**Minutes of Pre-SSDA Meeting held via MS Teams 2pm Friday 31 October 2025 – WSU
Milperra**

Meeting held following the provision of Pre-DA comments by Council to a package of information submitted in August 2025. Correspondence sent on 3 September 2025 to Mirvac, raising 88 items. The DA was announced as State Significant Development by the Housing Delivery Authority soon thereafter. This meeting was held to answer questions from the proponent about specific items in Council's correspondence of 3 September 2025. Minimal additional information was provided. Not all 88 items were covered. The majority remain outstanding as far as Council is aware/concerned.

COMMUNITY TITLE SUBDIVISION OF
PROPOSED LOT 30 CREATED IN
STAGE 3A

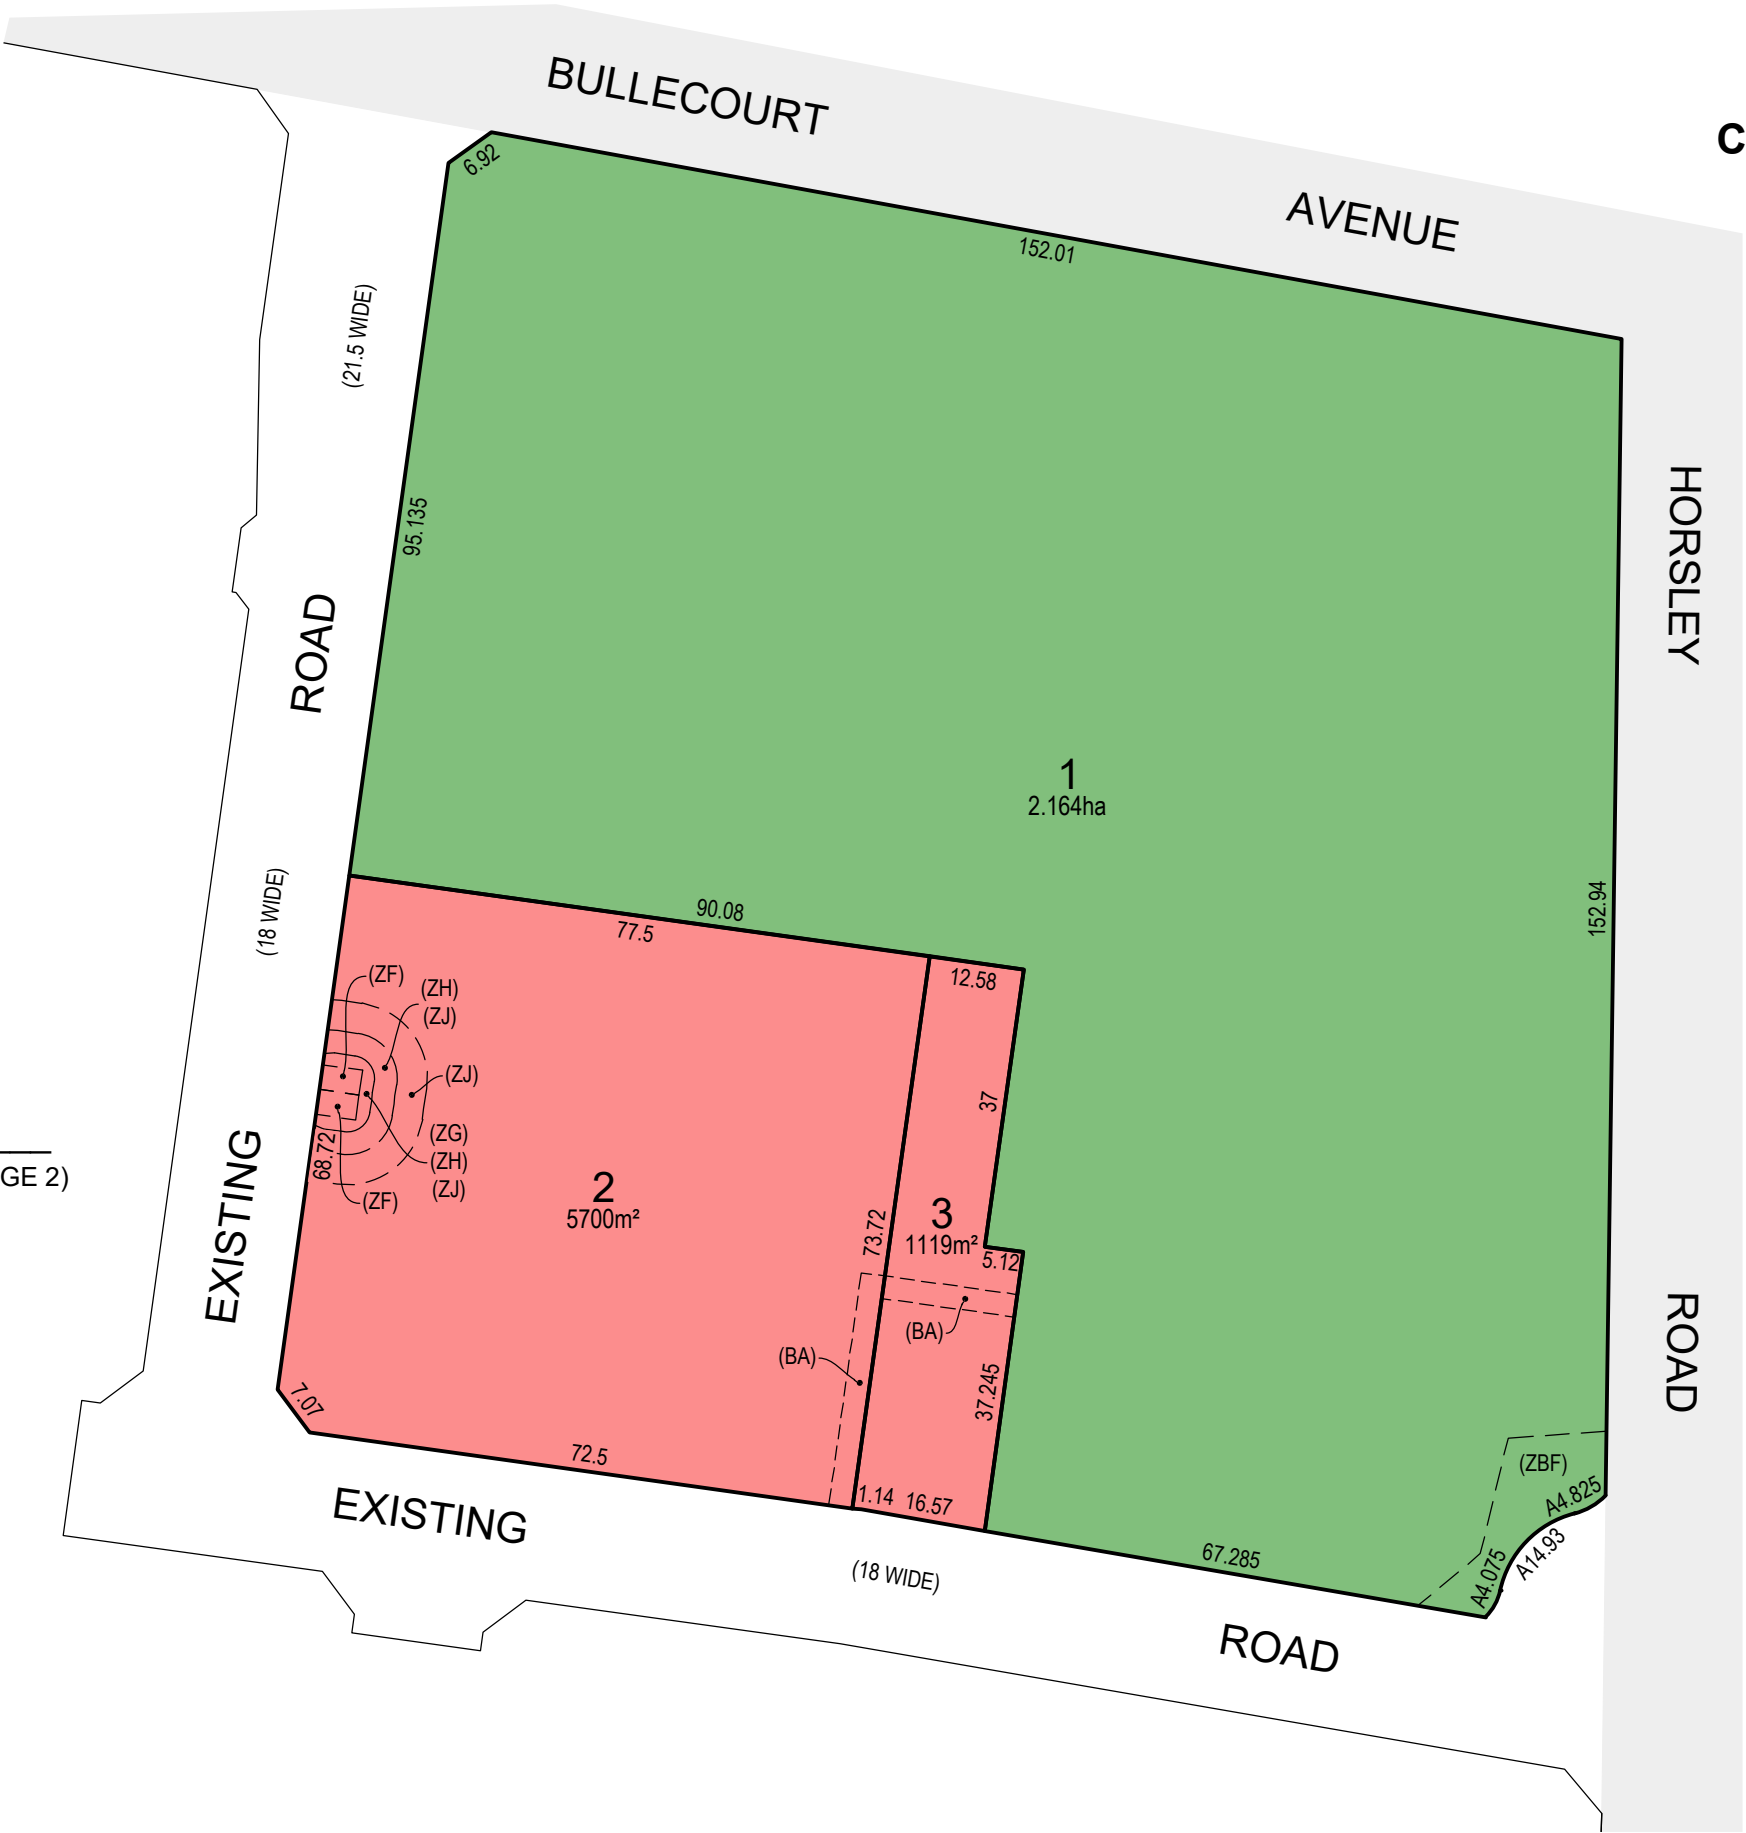
11. *The creation of lot 30 (E1 and C2 zoned land) and the inclusion of a further community title subdivision of proposed lot 30 has not provided sufficient detail for consideration. It is unclear on what the intention of this will achieve and currently it is considered it should not be pursued as part of the initial DA. Sufficient details have not been provided to demonstrate why this should be considered and form part of a DA lodgement.*

Ashleigh Ryan spoke, describing the Community title subdivision of proposed lot 30 into 3 further lots. Lot 1 will be the C2 zone, with various relevant details associated including vegetation management plans, tree protection zones, etc. Lot 2 will contain the existing Child Care Centre.

Lot 3 will be a future retail lot. Conditions on lots will remain to maintain Lot 1 (being environmentally sensitive land). Council offered no comment.

1 HYDRAULIC CONCEPT PLAN - LOT2101

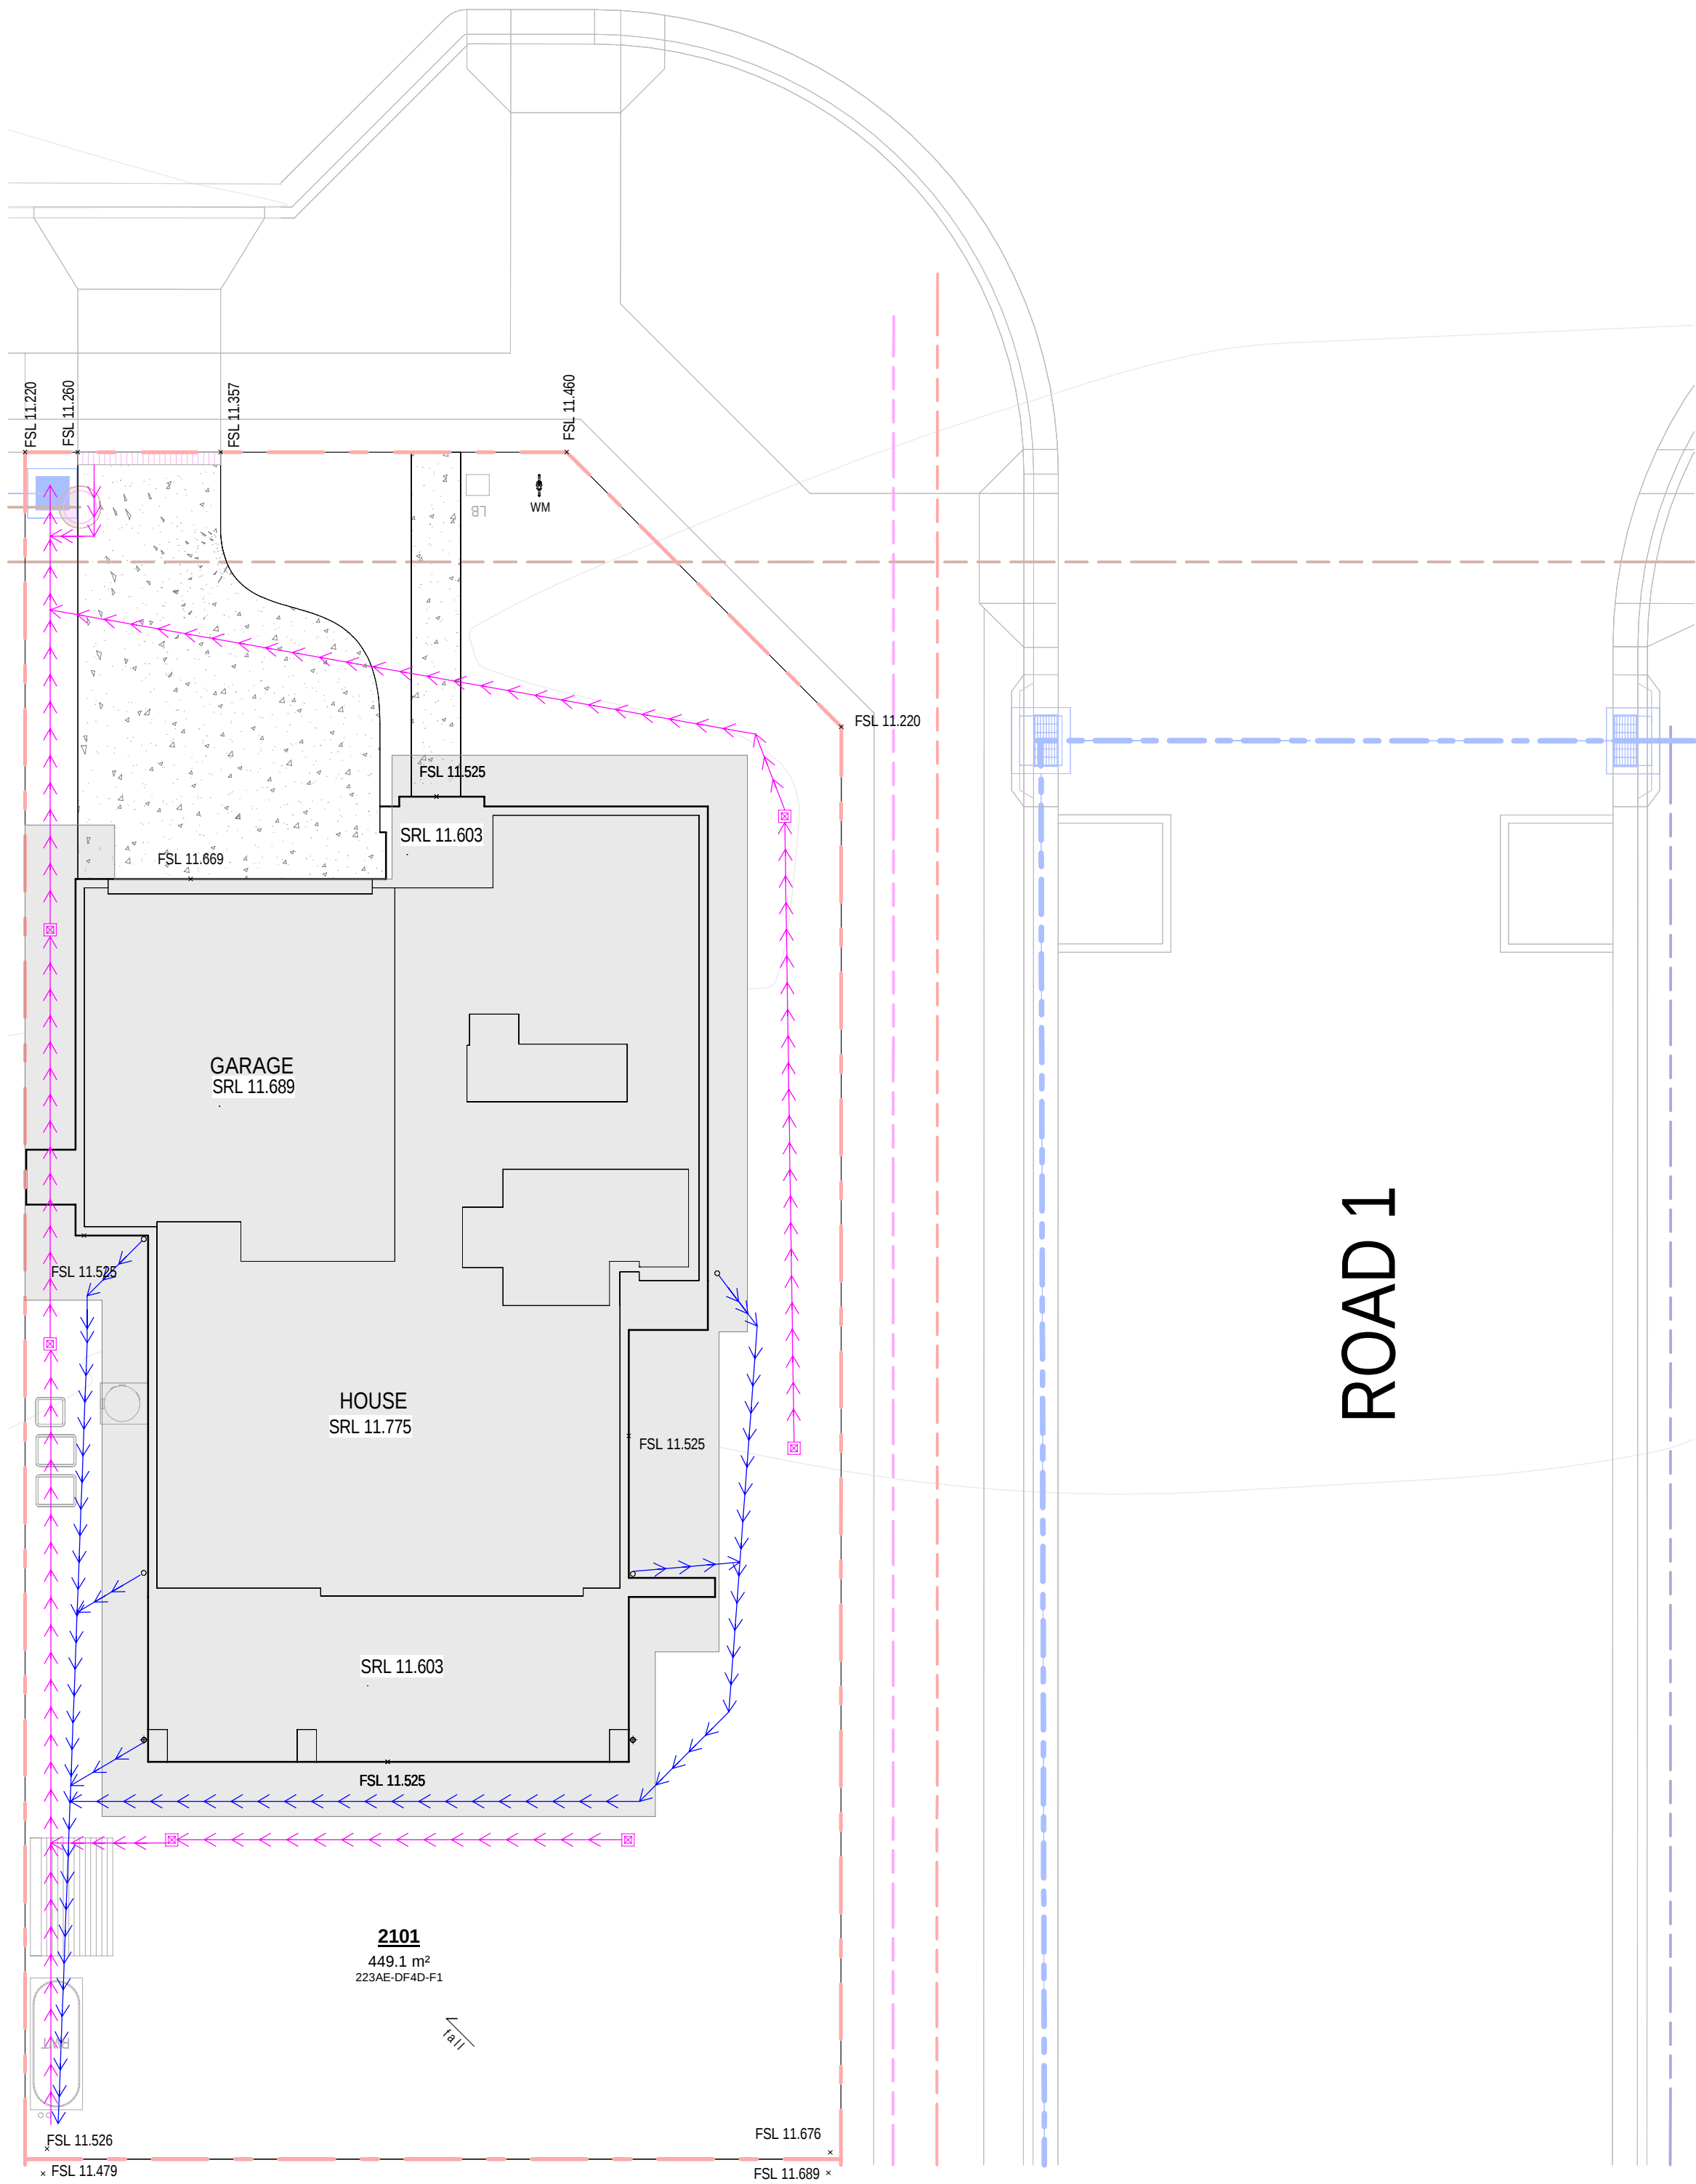
10. *Further details and an address of the driveway placement for lot 2101 must be provided. The current design and kerb extension on the allotment appears to result in a driveway that would not be suitable in the current location. This should be reviewed*

and where necessary the lot width increased to enable a suitable driveway location to be provided for accessing the lot (should the pedestrian crossing design be accepted).
